Planning Consultation Memo

| Date | Planning Officer | Environmental Health Officer |
|-----------------------------|------------------|------------------------------|
| 6/2018/2170/FULL | WK/102841 | |

Address: Garages and Land adjacent to flats 37-48 Lambs Close Cuffley EN6 4HD
Application Details: Erection of third flat on the airspace of 2x existing flats.

SECOND FLOOR PLAN

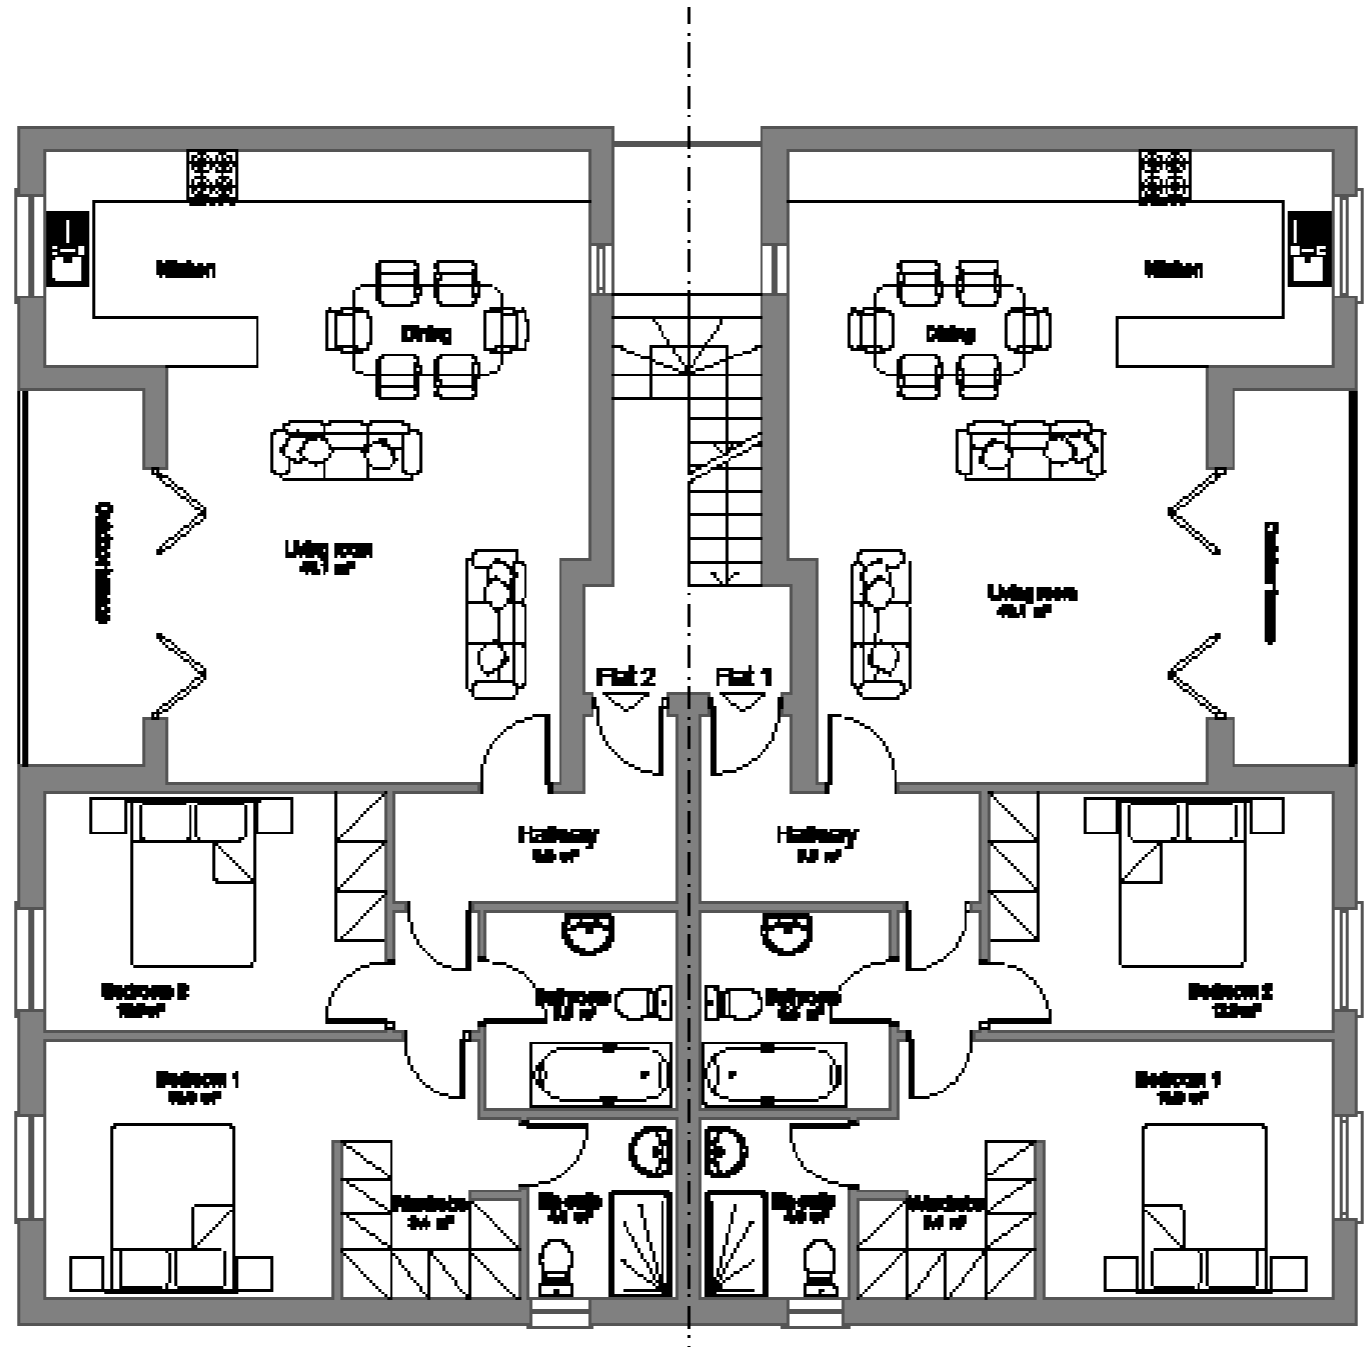
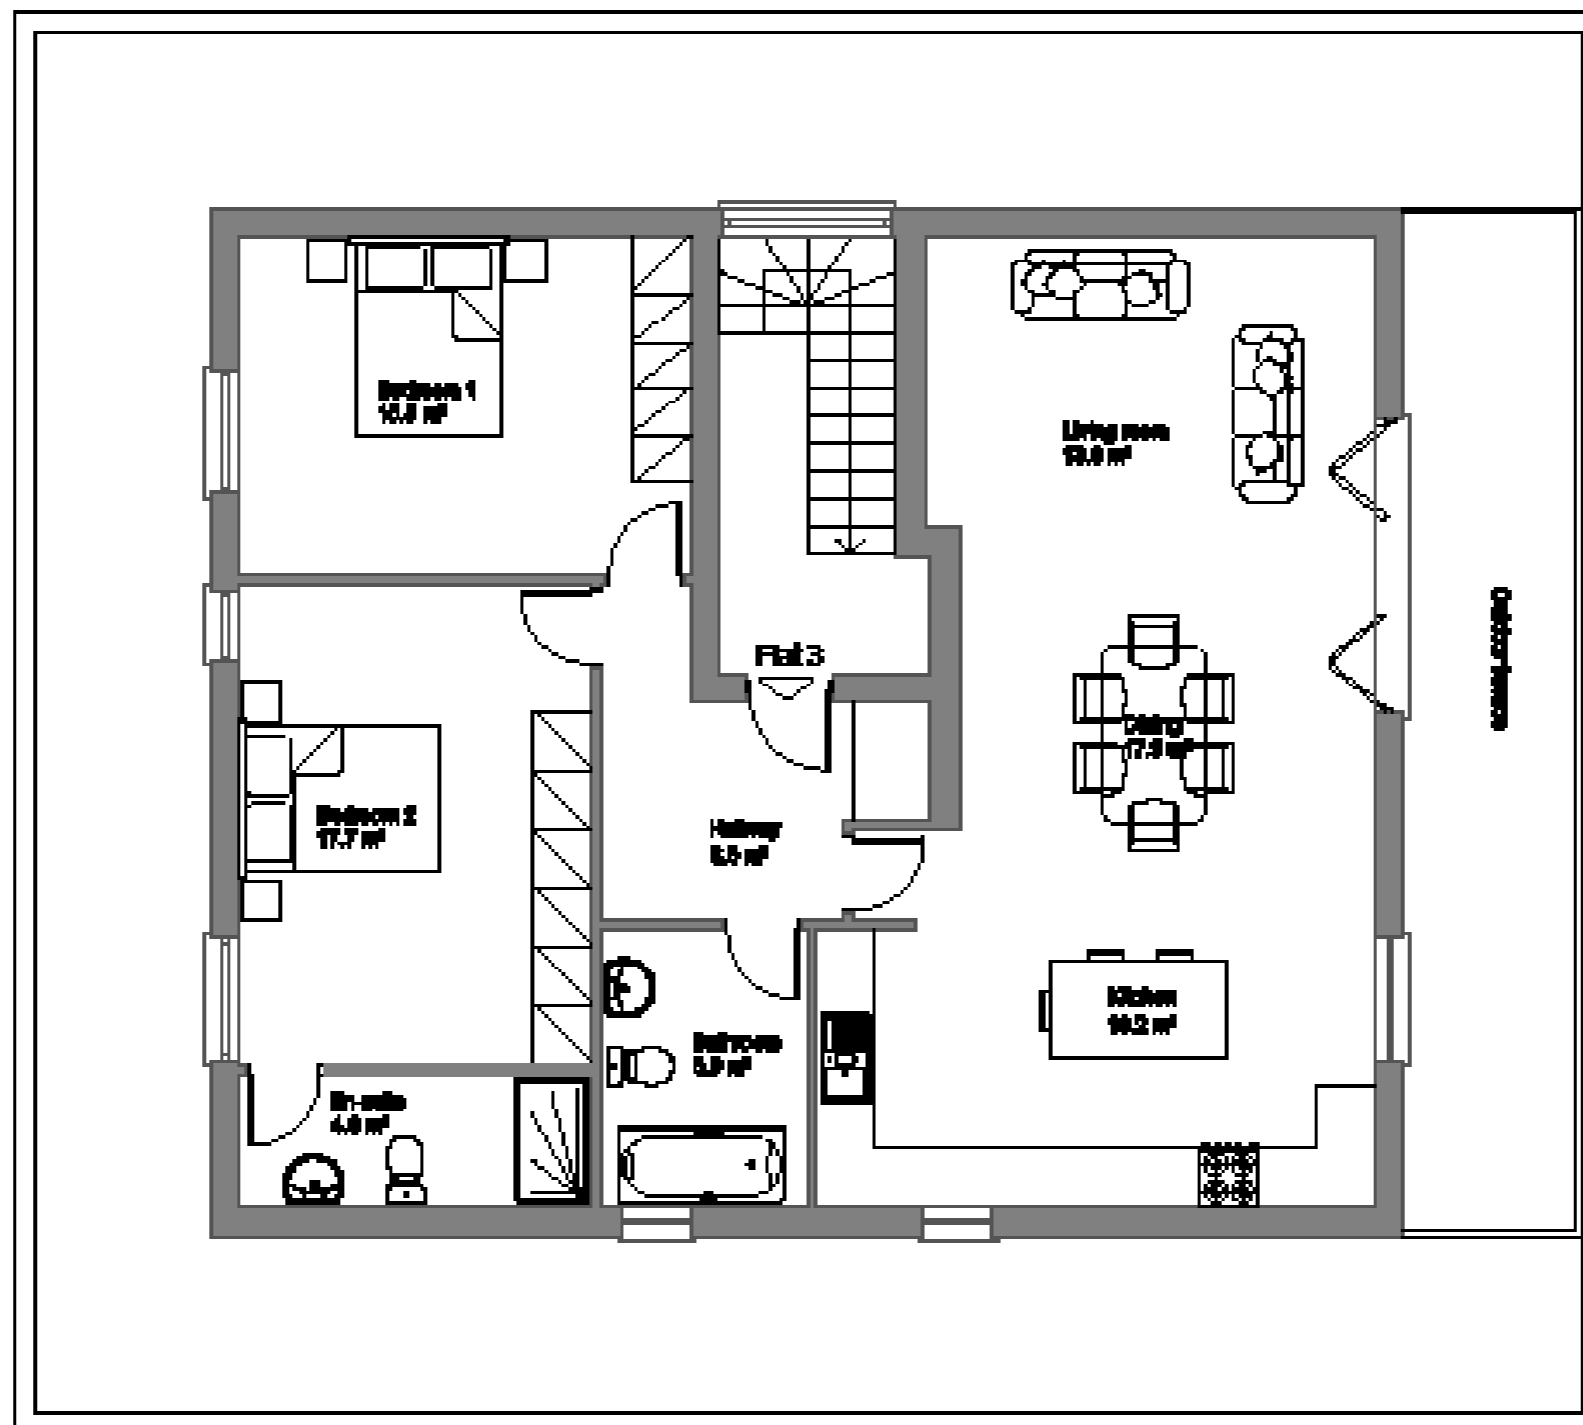
More detail is required on the impact of the railway line on the proposed development, especially in terms of max noise levels. Looking at the floor plans, if read correctly, shows that bedrooms will be shielded from the railway line, which should have an impact on quality of sleep.
